River Bend Crossing Traffic Impact and Access Analysis (LSC #184140) August 2, 2018

Summary of Comments on LSC Responses to EPC TIS Redline Comments.pdf

Figure 7a
**Short-Term
Background Traffic**
River Bend Crossing (LSC #184140)

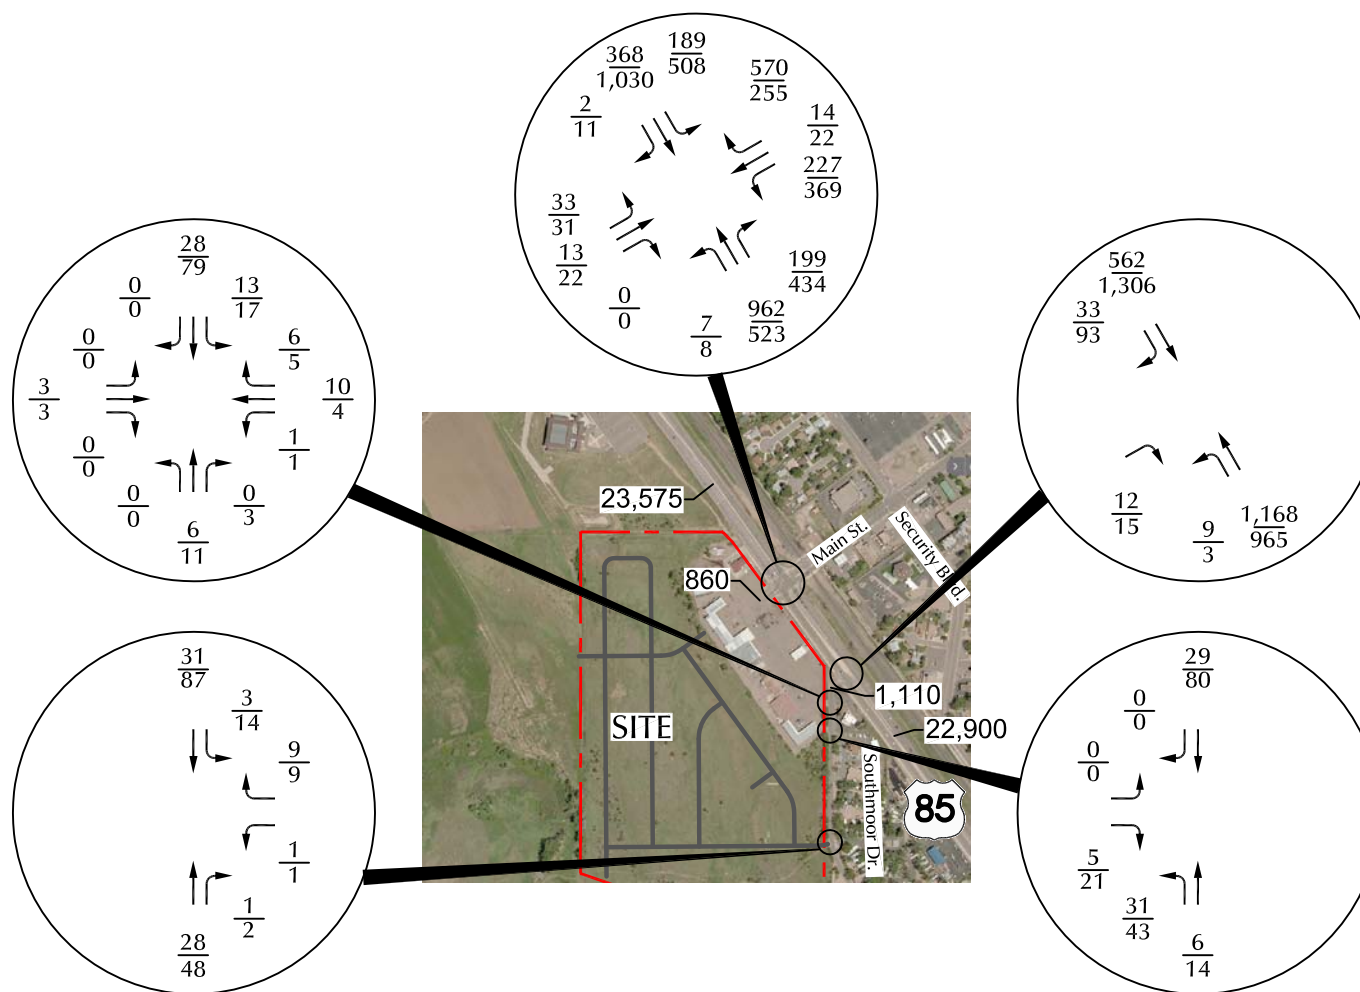
Clarify the last sentence. This seems to contradict the second paragraph below and figure 7a which shows trips in/out of Fountain Valley Shopping Center. Provide a more detailed explanation on the method used to exclude traffic going in/out of the shopping center.

Author: Kirstin Subject: Sticky Note Date: 4/25/2019 1:59:25 PM
done
